Planning Application: 3/2026/0529

Proposal: Approval of part of details reserved by condition 5 (programme of archaeological work for the site of the temporary River Ribble Crossing and associated haul road and compounds) of planning permission 3/2021/0661.

STRABAG's Written Scheme of Investigation, is lacking the following:

Figure 1 Phase 1 - Enabling and Site Establishment Works associated with the River Ribble Crossing

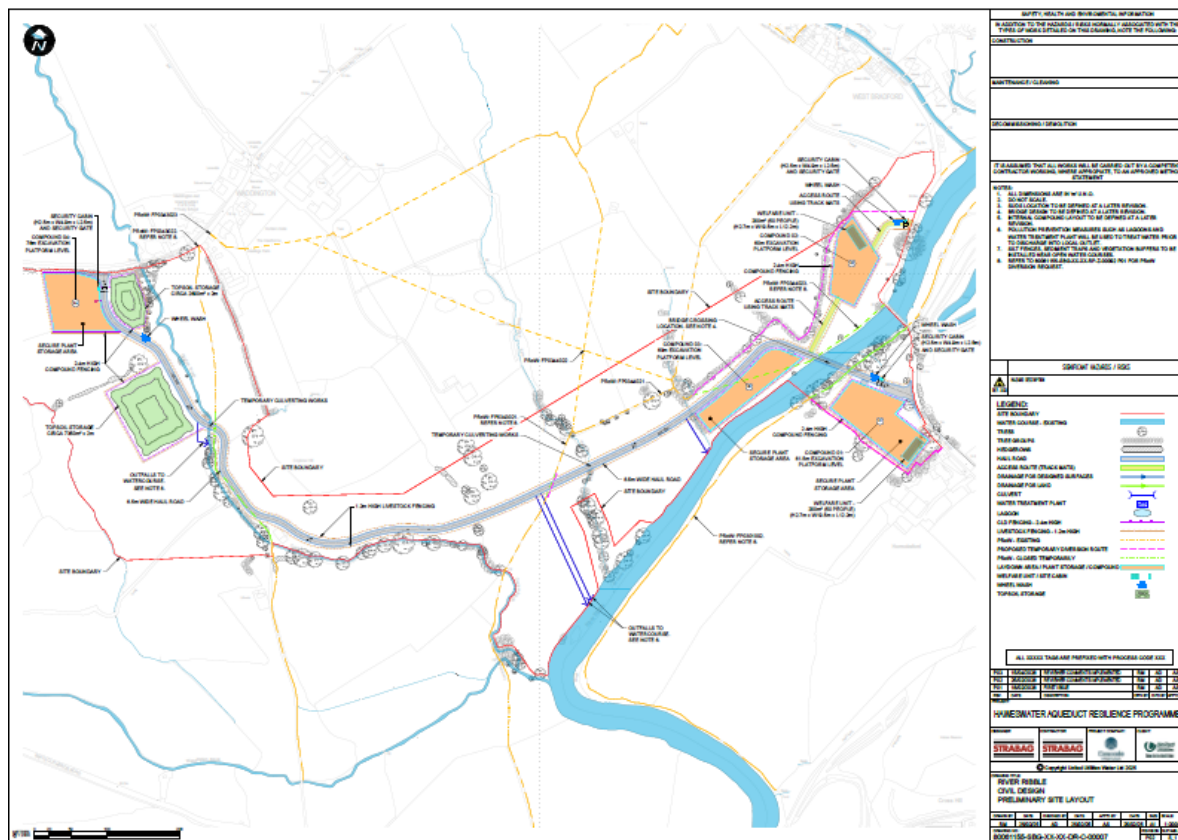
a revised Figure 1 that more clearly shows all the proposed phases of work (masterplan), or by a set of plans showing each individual proposed phase.
